Land at Drove Lane, Yapton
Surface Water Drainage Statement Addendum

(Document ref. 133647-SWDS-01C)

This updated addendum is to be read in conjunction with Document Reference: 133647-SWDS-01A and all relevant drawings to support the reserved matters application for the development site at Drove Lane, Yapton.

Granular Blanket Below Detention Basin
Pond 2

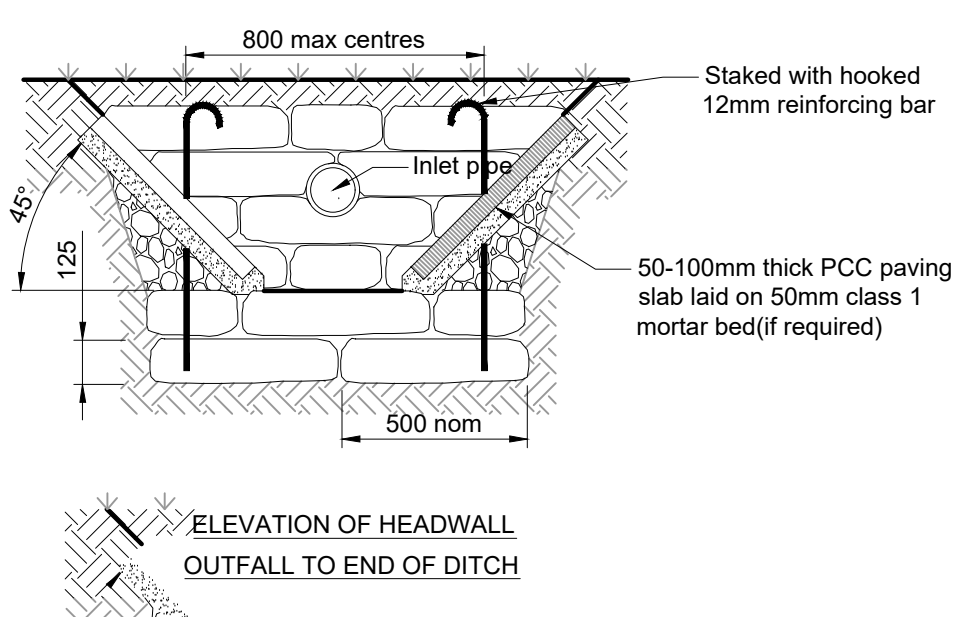
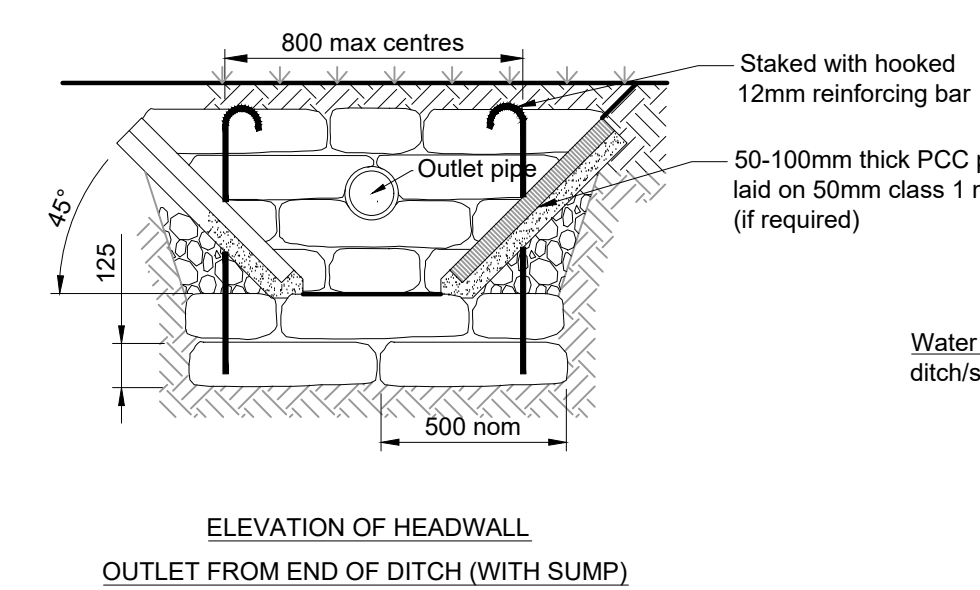
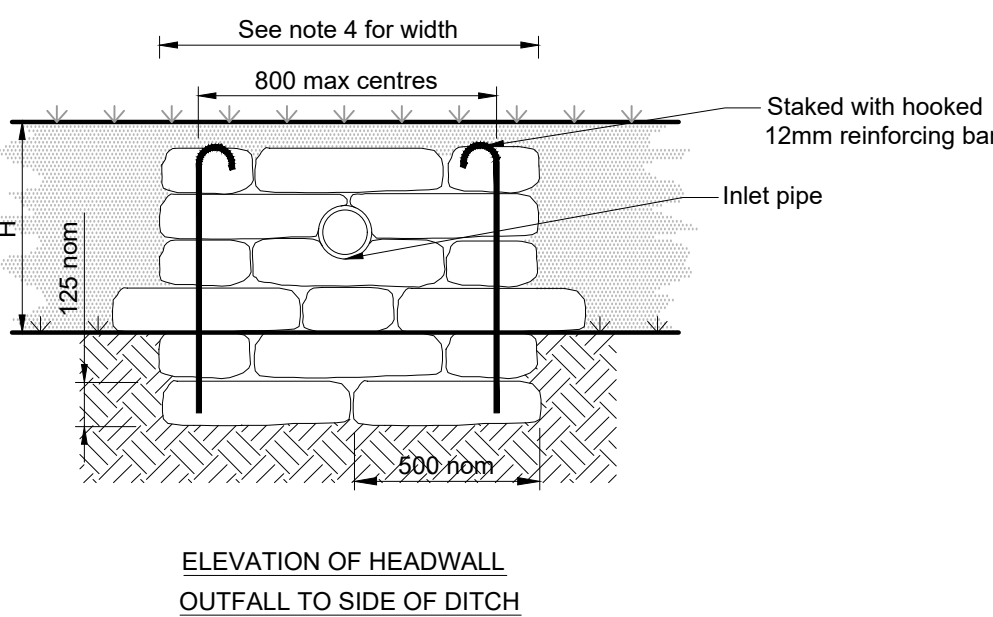
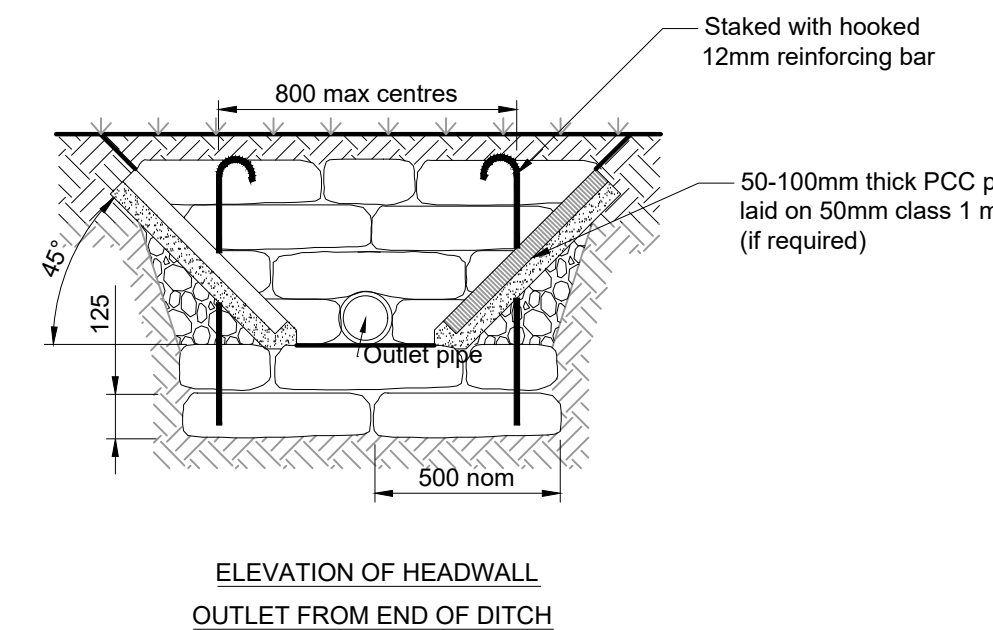
- ¿ Orifice details have been added to the drainage construction details.
- ¿ Pond 2 is not lined. All features that are below the worst case ground water level from the winter monitoring have sufficient permeability to allow water to ingress and egress.

Enhanced swale with 225mm Ø 360° perforated pipe SW1, SW3, SW4, SW5, SA5, All Roadside enhanced swales

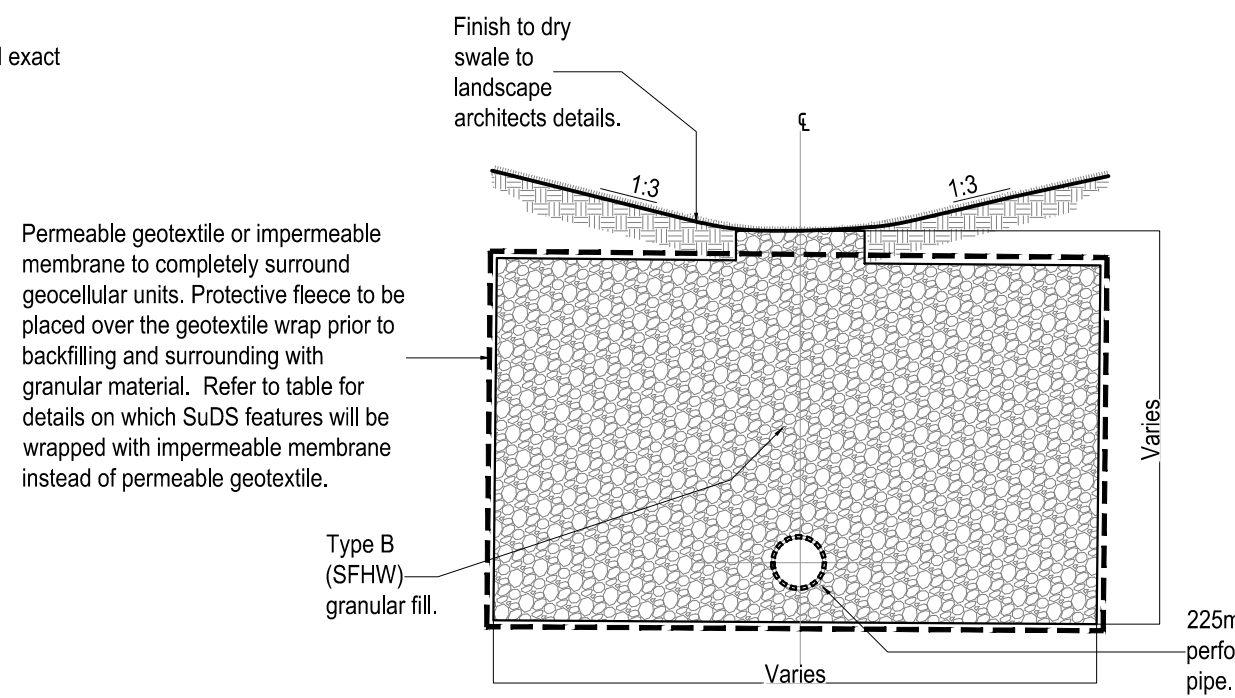
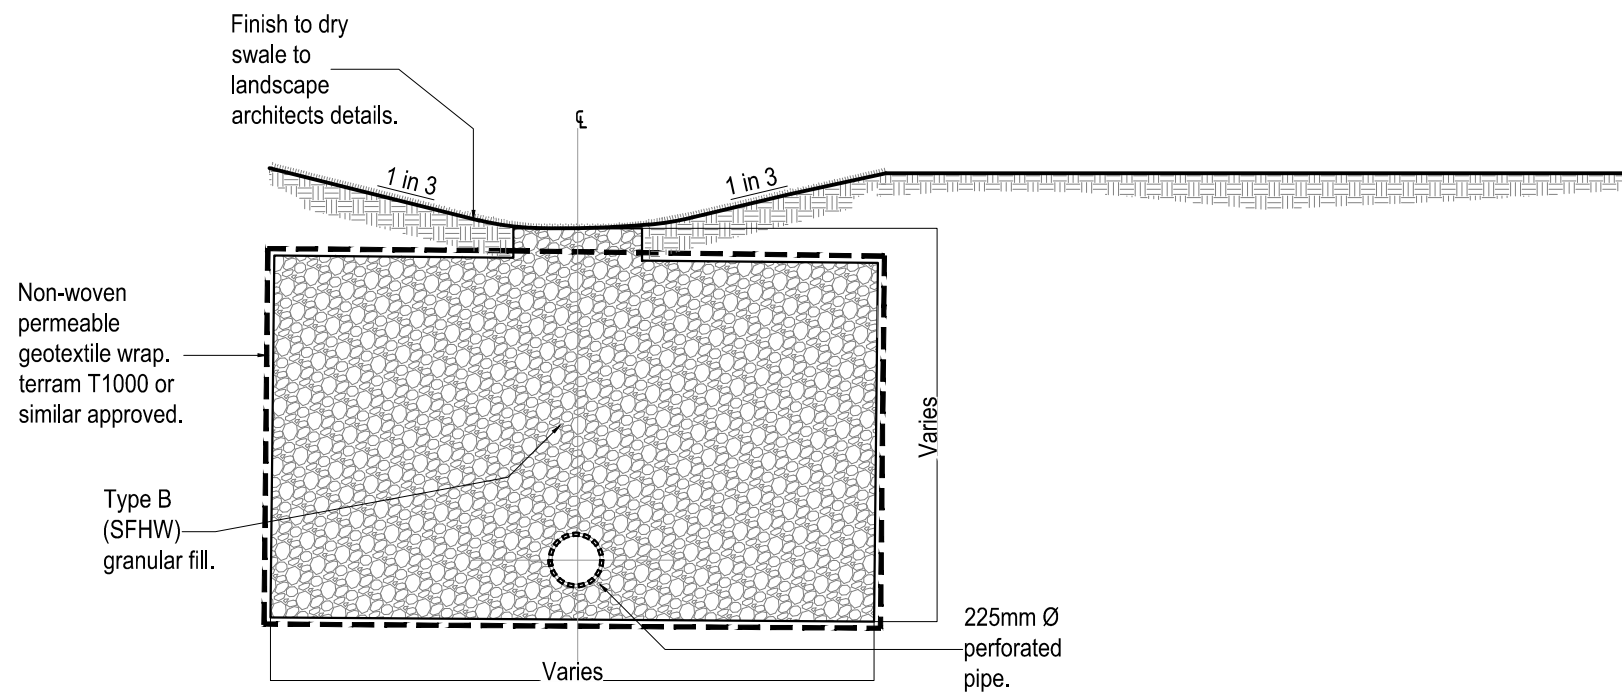
- ¿ We include construction details of the swales with references to the swales on plan.
- ¿ We include details of all drainage features employed in the drainage network.

- ¿ With the swales and cellular storage being of the same construction, we agreed to provide one representative construction detail for the enhanced swales and one for the cells. We have also provided construction details for each SuDS feature scenario encountered on this site.

Permeable Paving Connection Detail To Proposed Surface Water Network

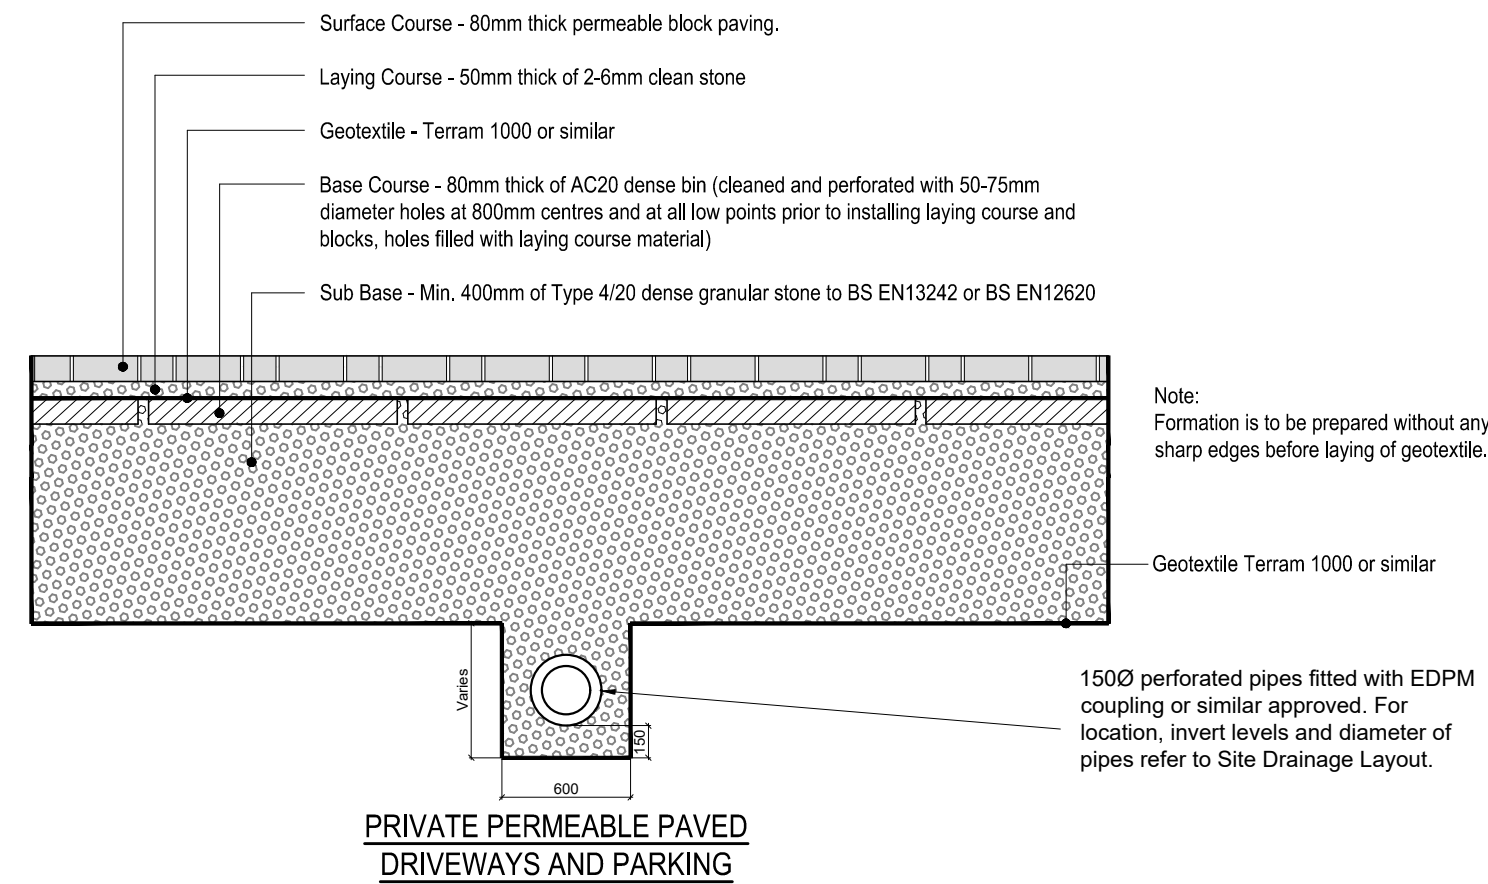
- ¿ A typical detail to show the connection of permeable paving into the drainage network has been provided with the updated application.
